MECKLENBURG COUNTY
Park and Recreation Department

MEMORANDUM

DATE: January 24, 2023

RE: Rezoning Petition #2022-121
PID# 22502106

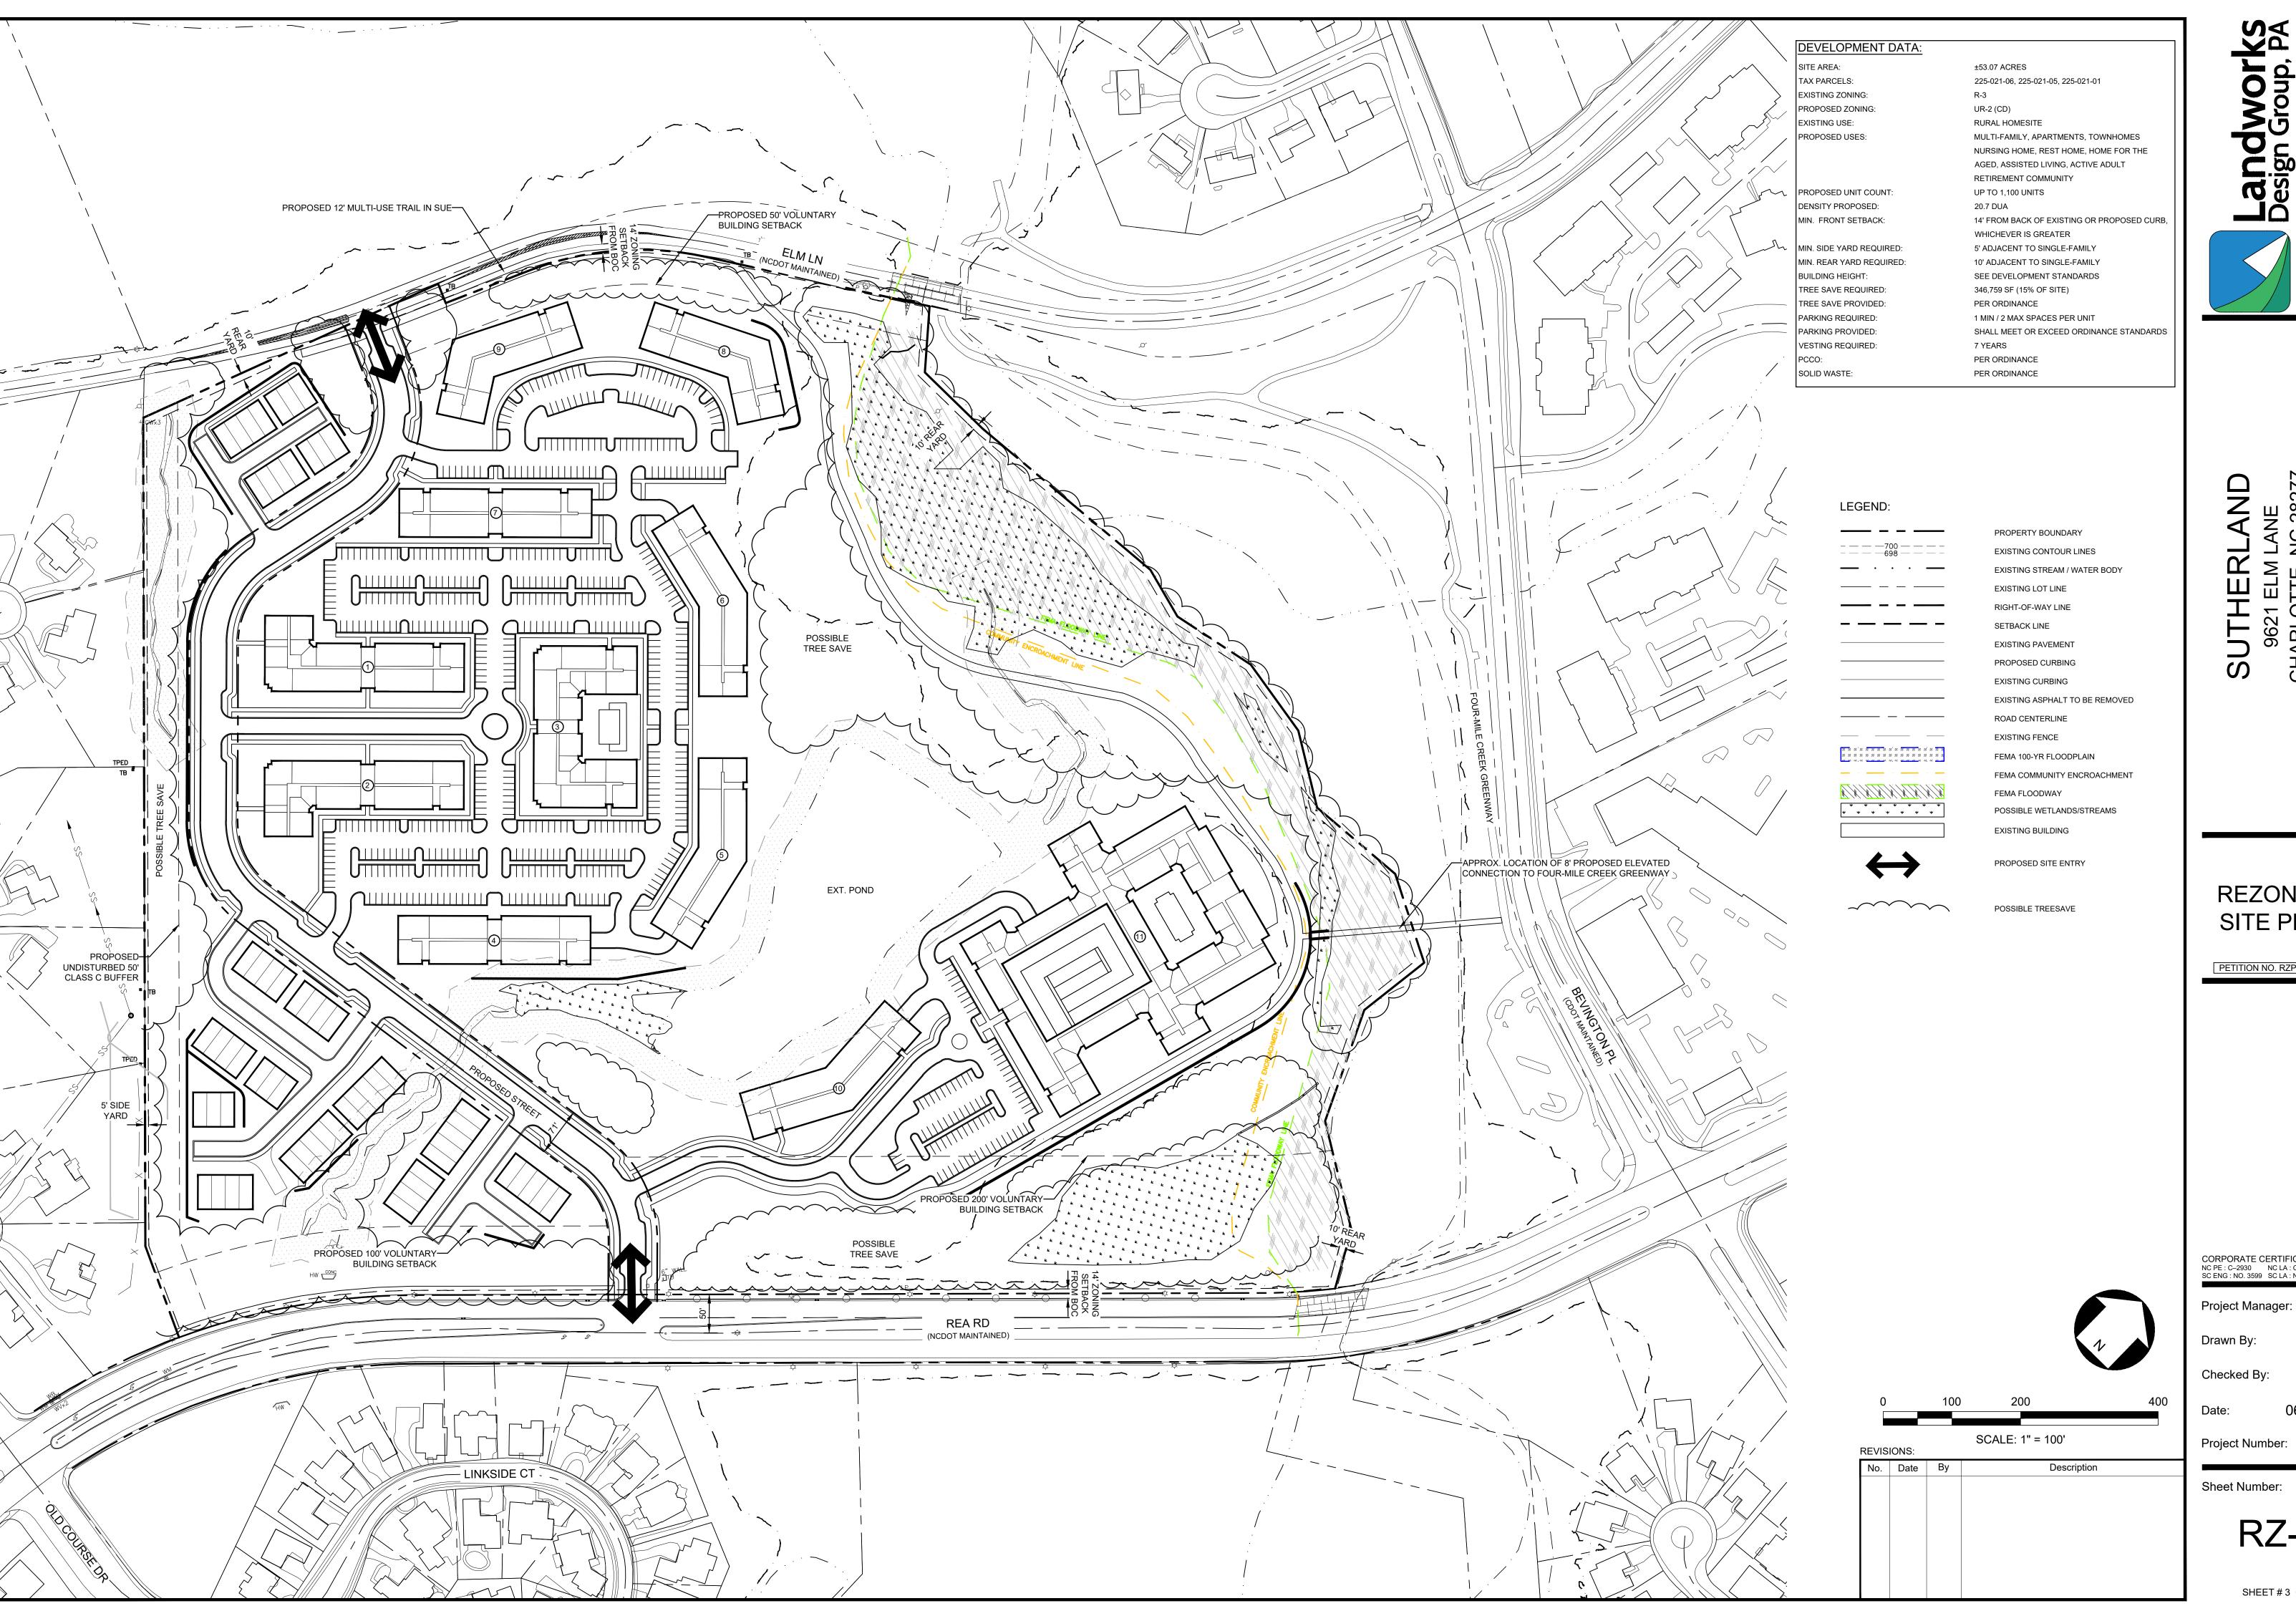
Plans show a private trail connection from Elm Lane and Rea Road to Four Mile Creek Greenway. Please confirm if the trail will be privately maintained with public access, or if any of the trail is intended to be dedicated to Mecklenburg County. The proposed trail connection and any trail constructed on Mecklenburg County property will need to be coordinated with County staff, built to County standards, and the developer would need real estate approval for any work completed on Mecklenburg County property.
